DELEGATED HOUSEHOLDER DECISION

original house by 4.00 metres, for which the maximum height would be 3.65 metres, and for which the height of the eaves would be 2.69 metres

PROPOSED GROUND
FLOOR PLAN

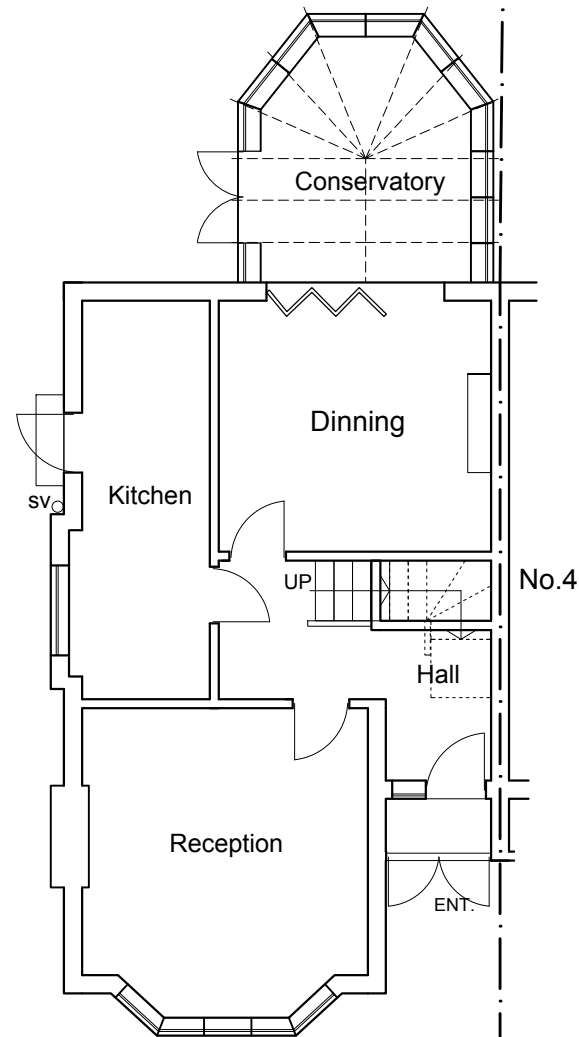
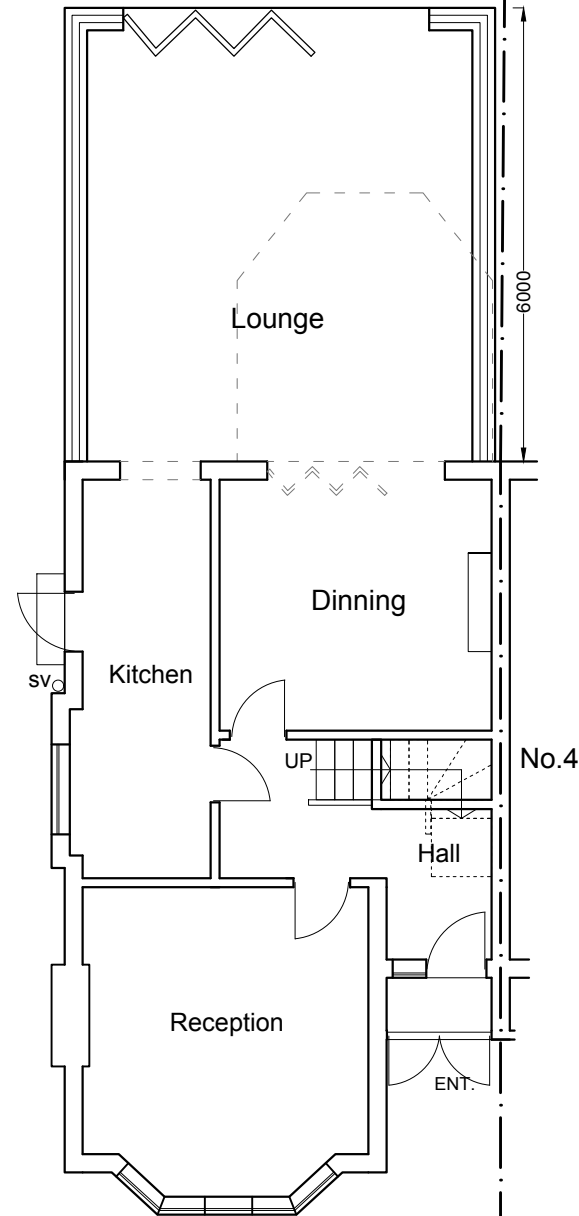
The proposed extension is projected to be 6m from the rear building line, 3.6m in height with a sloping roof, which would go down to 2.6m, having 5.6m in width. As outlined above, the proposed depth would not align with Part B of Policy DMHD 1 of the Hillingdon Local Plan: Part Two - Development Management Policies (January 2020).

Furthermore, the proposed extension would tower significantly over the boundary, by reason of its maximum height of 3.6m, which significantly exceeds a standard 2m means of enclosure. Given that on site there is already an outbuilding, the proposed scheme alongside the outbuilding would constitute an overdevelopment and the addition of both structures within the rear garden would fail to constitute subordinate additions.

Given the excessive width, depth and overall massing, the extension would dominate the host property and would therefore fail to harmonise with the character and appearance of the existing semi-detached properties. As such, the proposed extension would ultimately constitute as over development and over extend past the rear of the pair of semi-detached houses; which would result in an unseen feature within the immediate context of the site. Upon analysis, the proposed extension would substantially break the rear building line of the properties, and would therefore, fail to conform with the prevailing character of the surrounding area. On balance, the extension would not consider appropriate contextual design guidelines and therefore would be seen as an obtrusive form of development when viewed from neighbouring properties.

Limit to daylight/sunlight and loss of visual outlook would occur, as the rear extension is looking to project 6m from the rear building line. The development, when added to the existing outbuilding within the site, would be considered to be significant, resulting in an over development.

Given the development on site and alongside the proposed development; an insufficient amount of rear garden space would be retained to meet the needs of a family sized house, in accordance with Policies DMHD 1 and DMHB 18 of the Hillingdon Local Plan: Part Two - Development Management Policies (2020).

PROPOSED REAR
ELEVATION

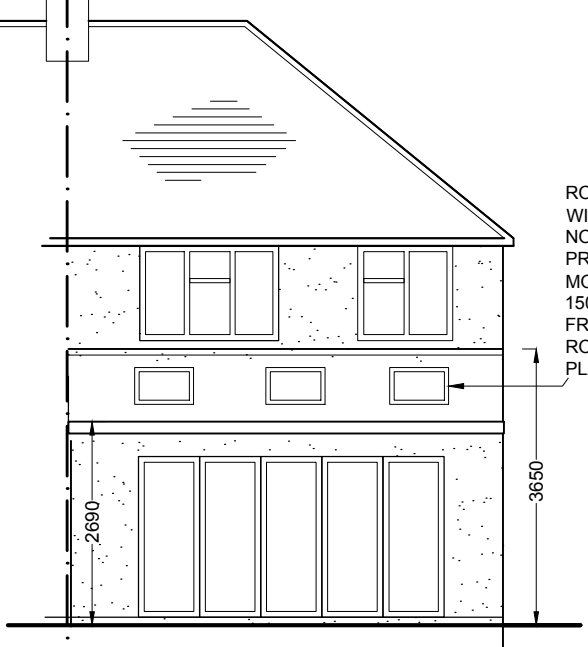
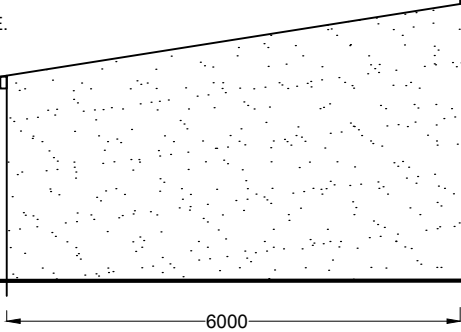
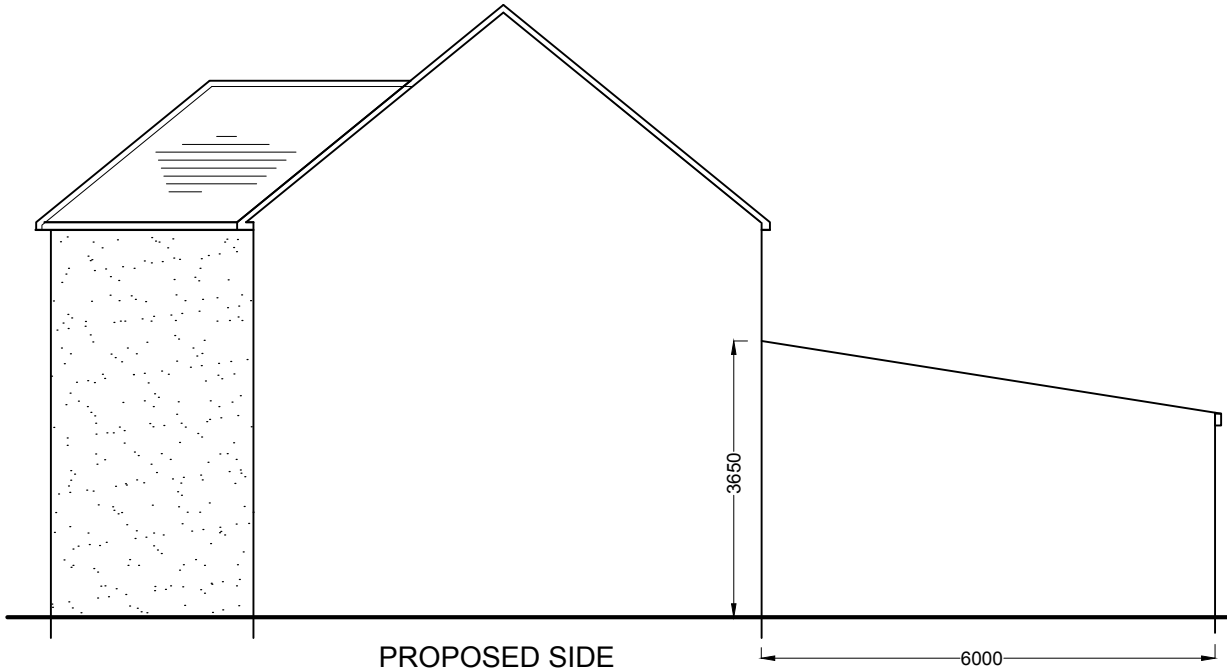
The proposed single storey extension is very bulky in scale, and would result in a disproportionate addition.
